From: Anita Gardner
Sent: 17 December 2018 15:30
To: Lynnyrd Wolfe
Subject: FW: LU/260/18/HH 22 Roman Acre, Littlehampton
Attachments: 1179.02.d Proposed A1.pdf

From: Lauren Willard [mailto:lauren.willard@inspired-design.co.uk]
Sent: 13 December 2018 17:37
To: Anita Gardner
Subject: LU/260/18/HH 22 Roman Acre, Littlehampton

| Drawing Number:  | 1179.02.d                                                 |

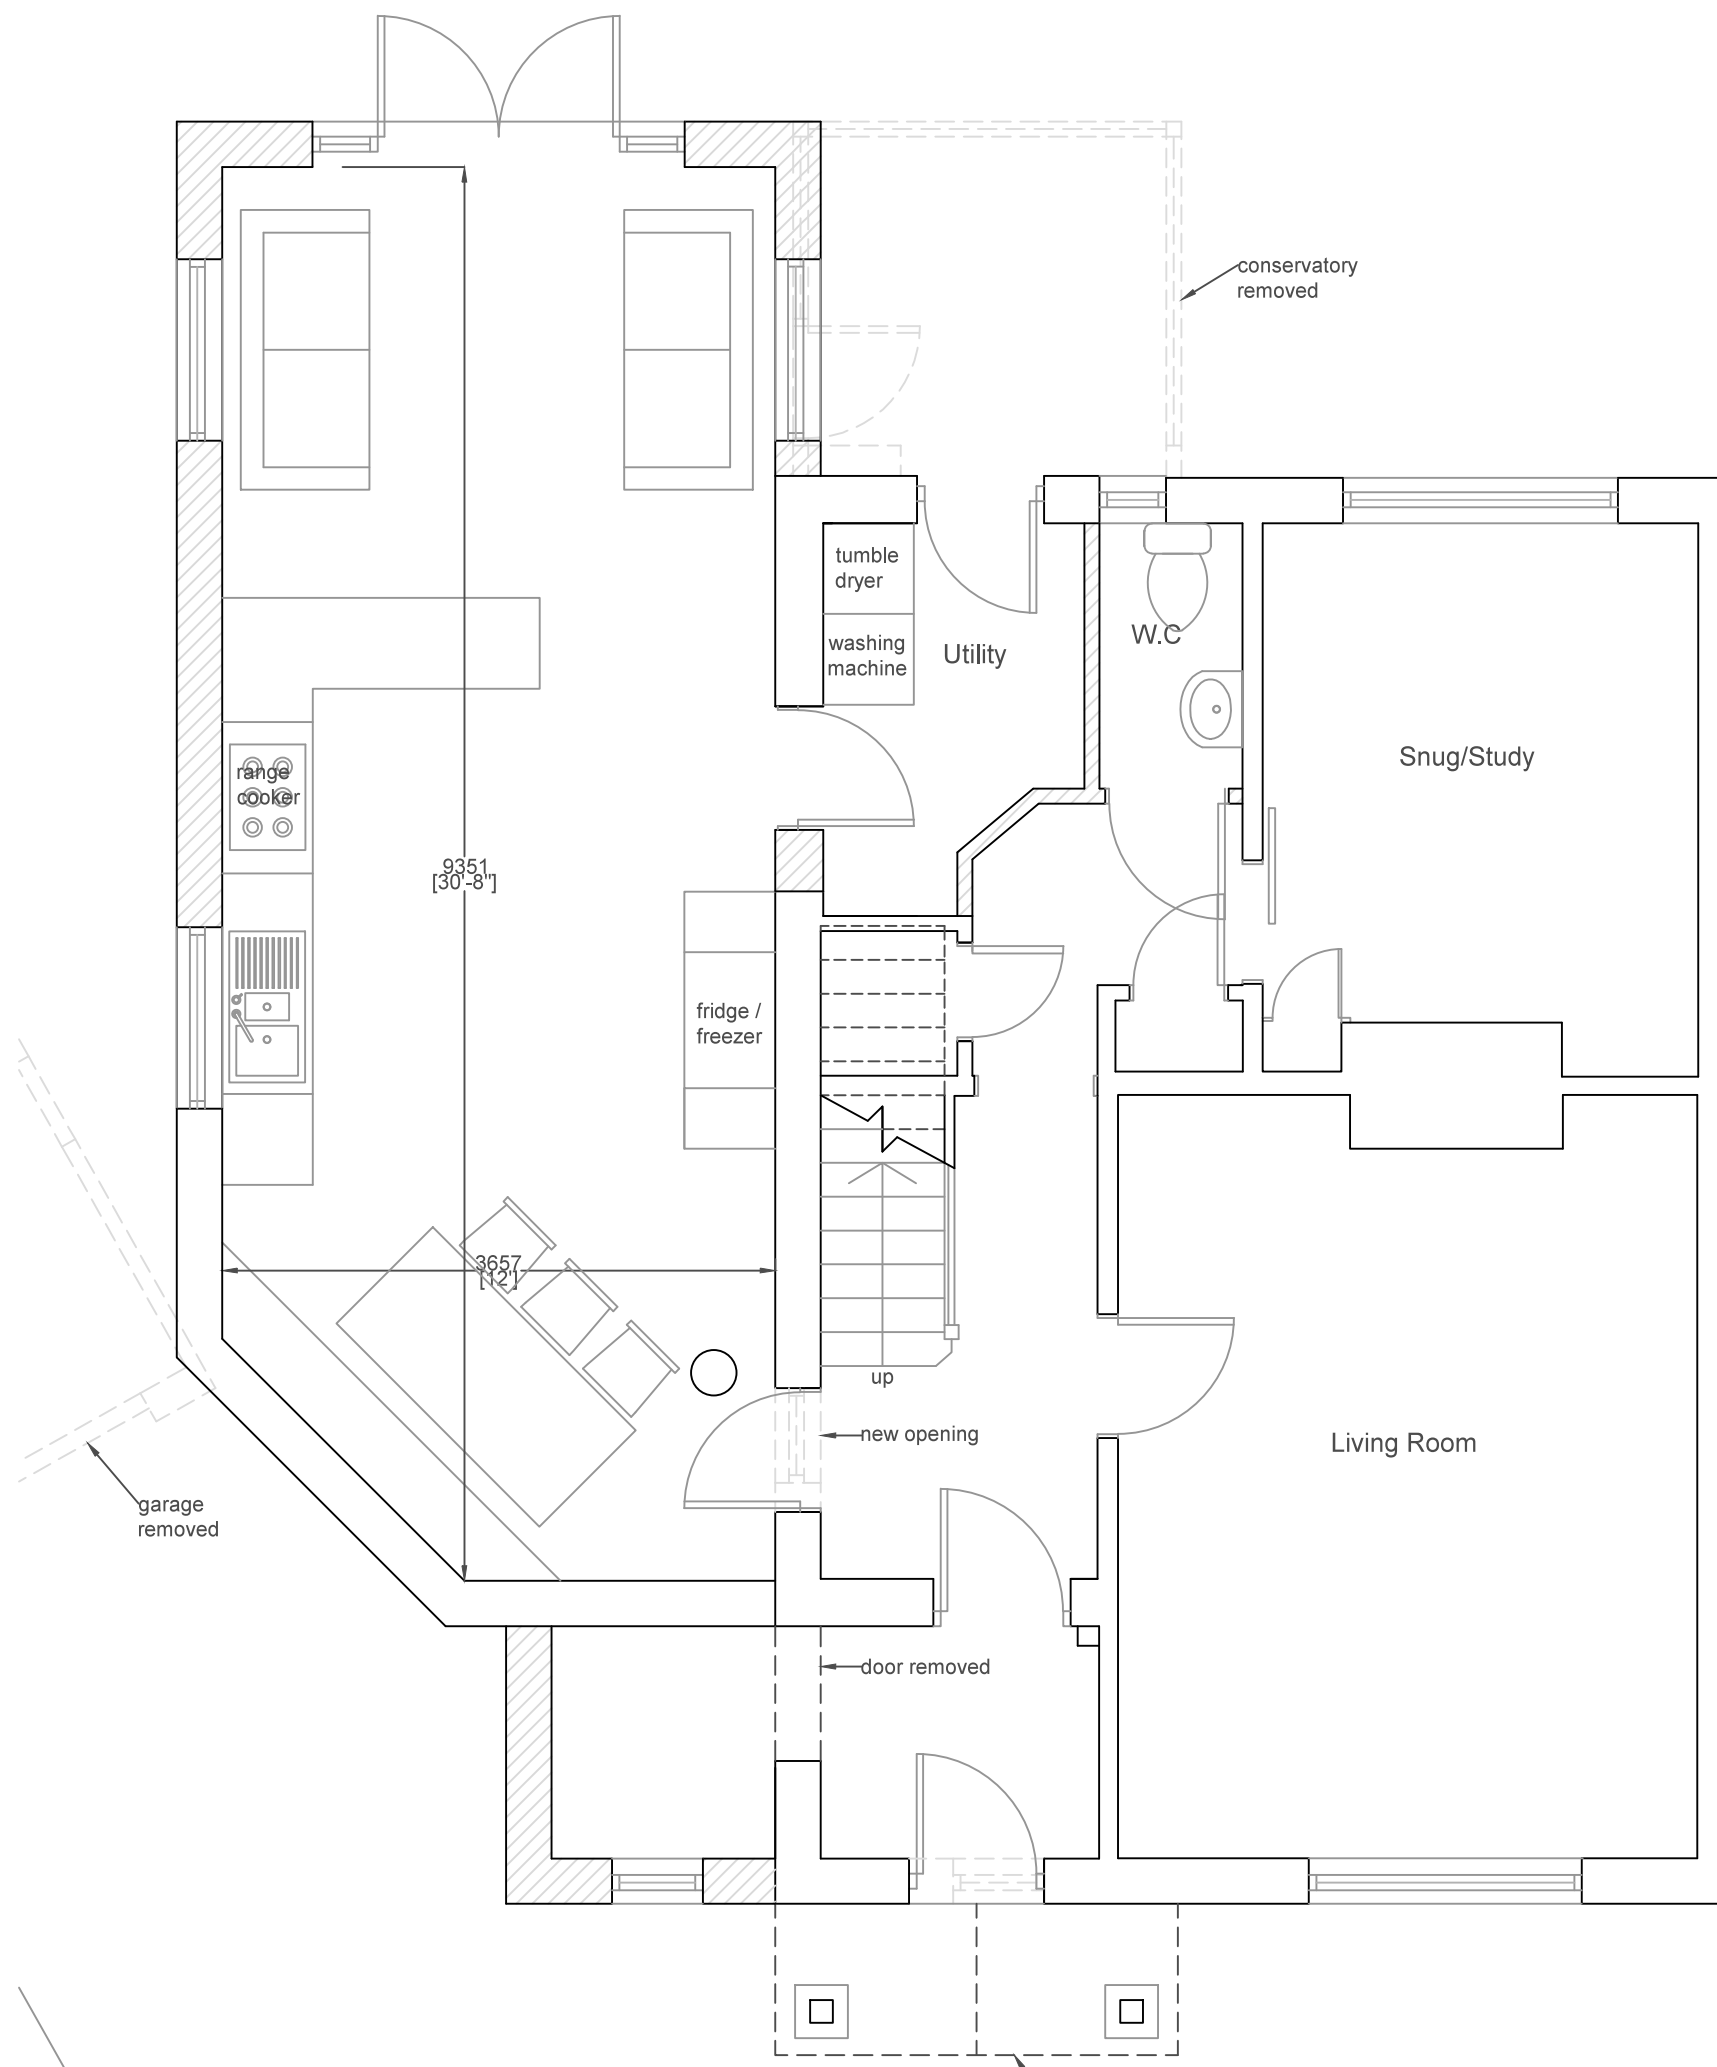
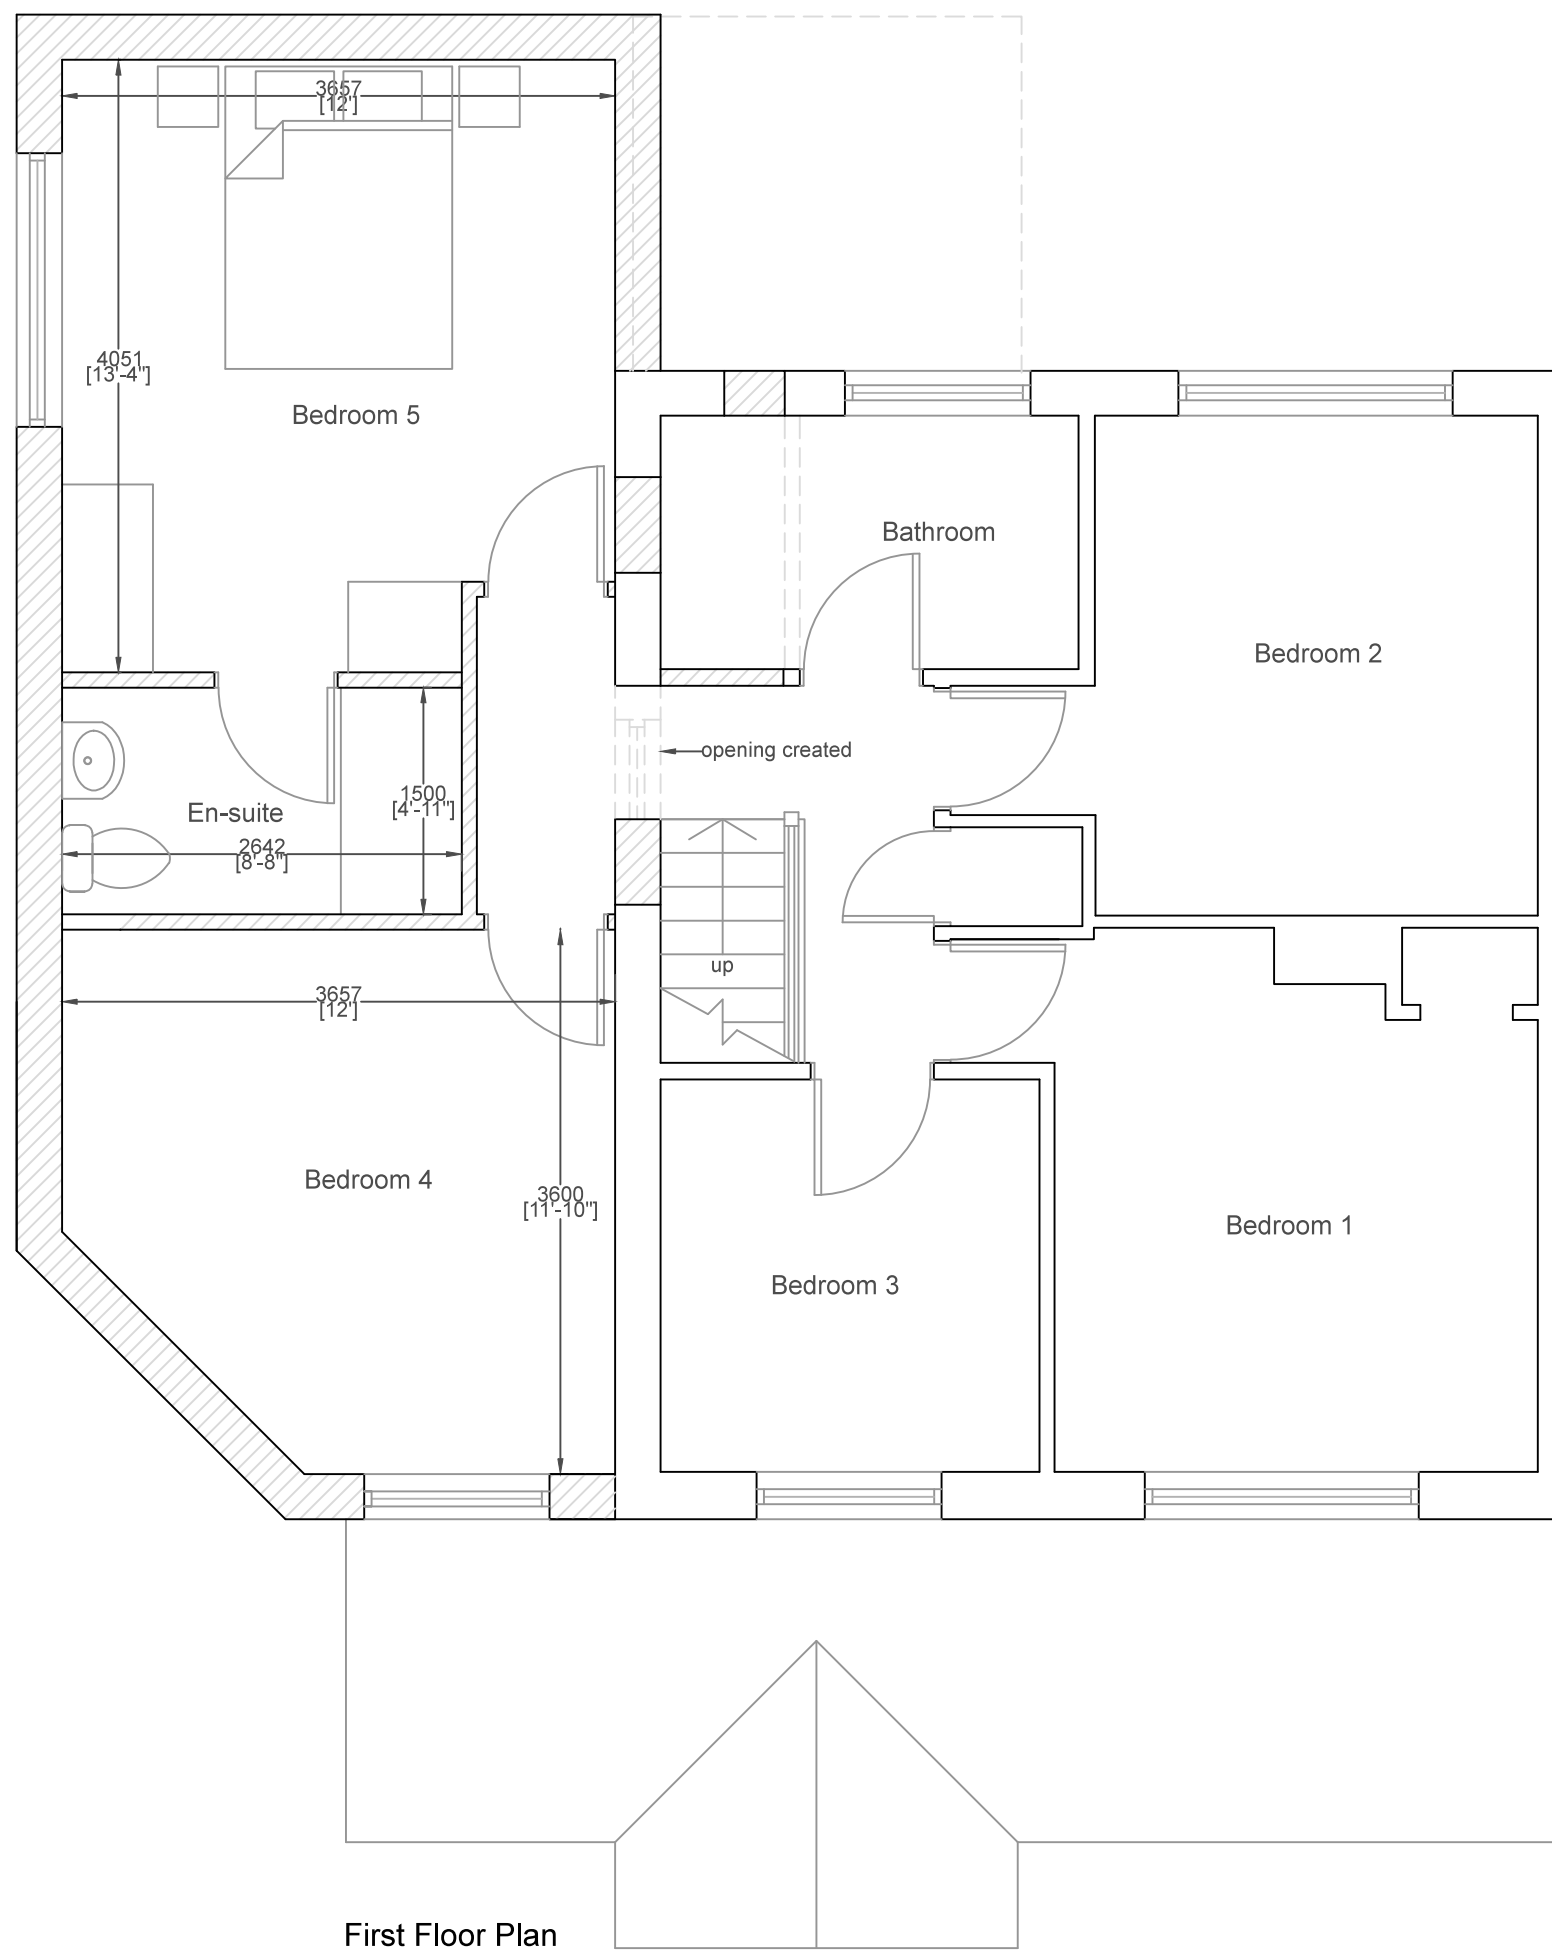
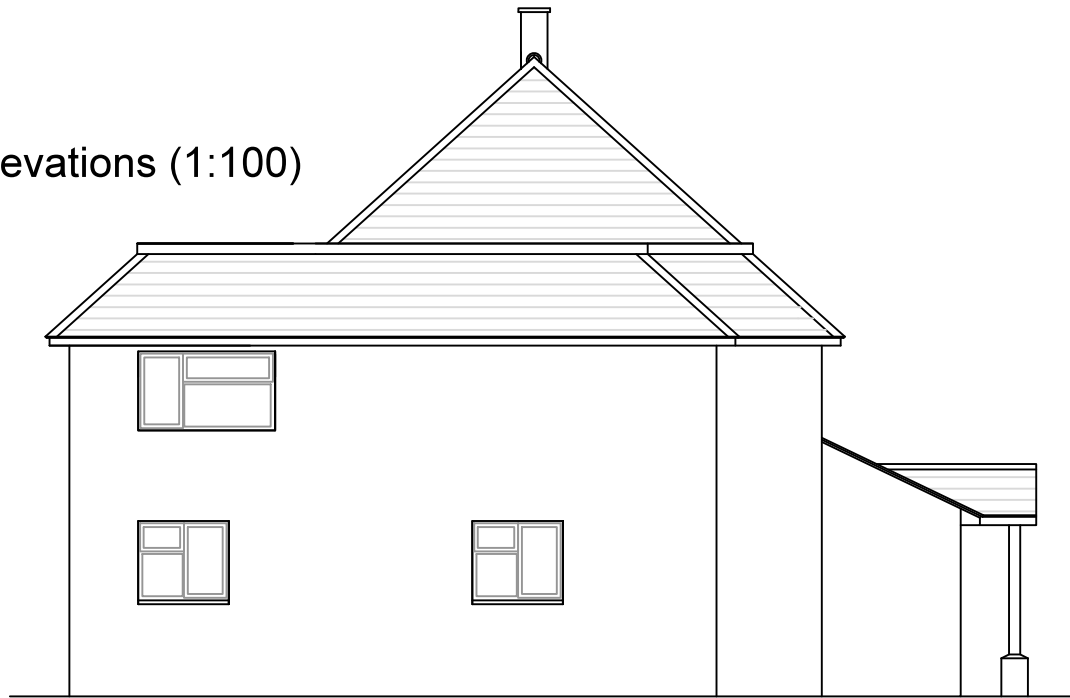
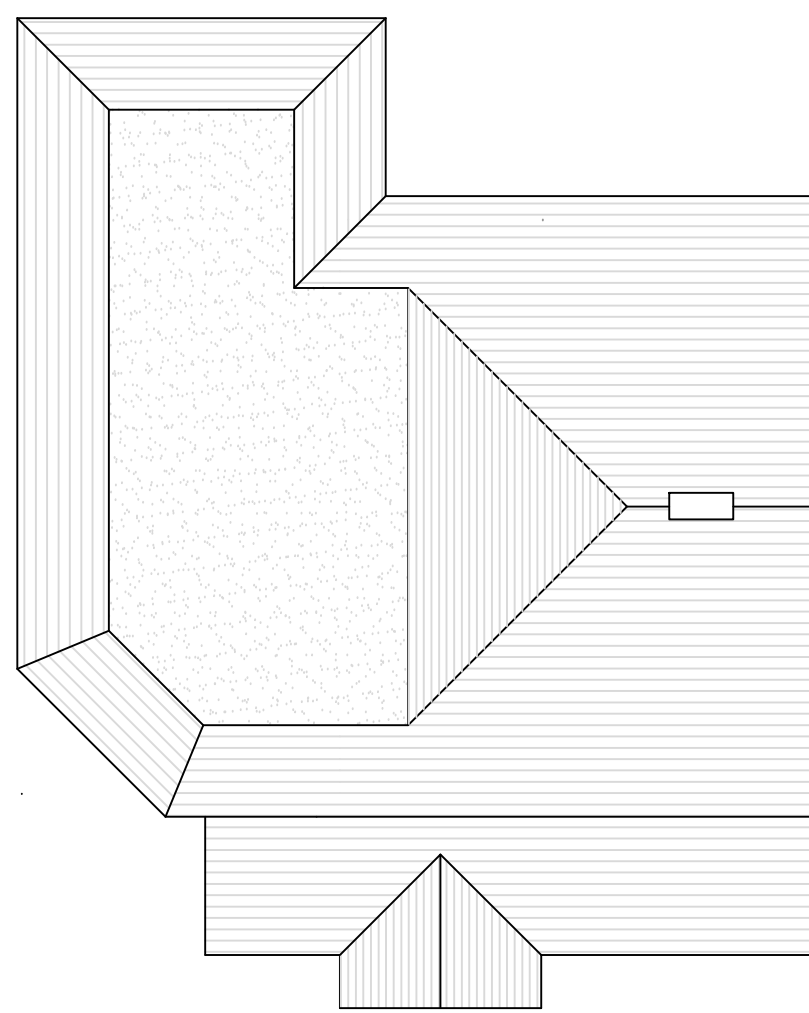
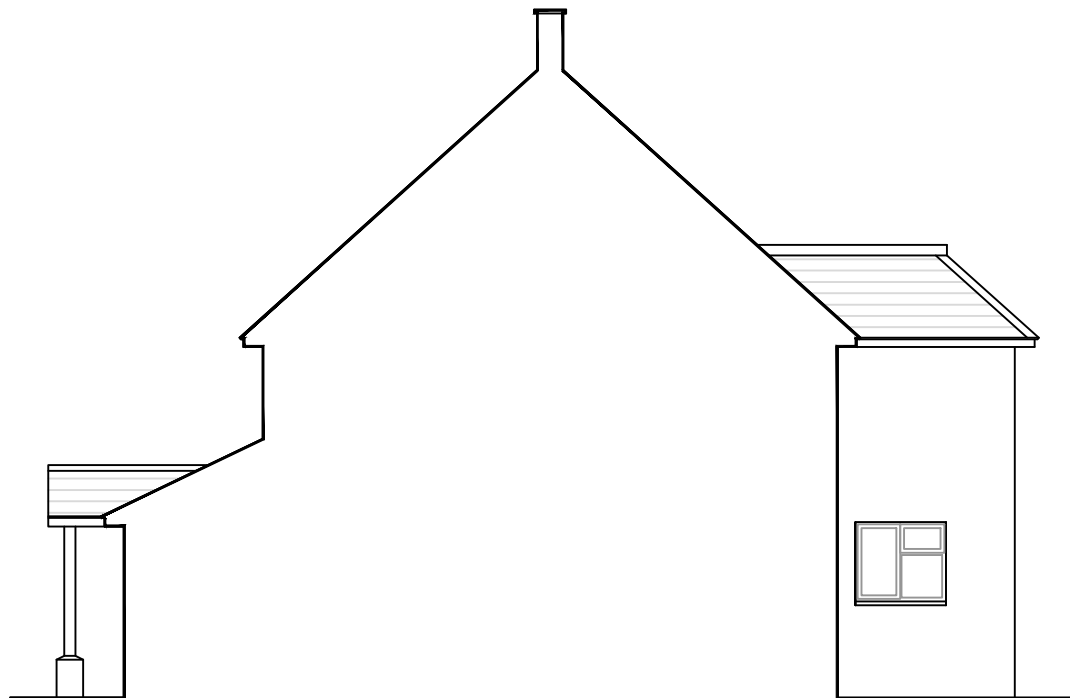
There is a change that the client would potentially like to move the side of the proposed extension out to the side of the property by an additional 300mm would it be possible to substitute a revised drawing for this? I will be able to get this to you tomorrow (Friday) if you would accept it.

Please find attached the amended drawing that we would like to substitute.
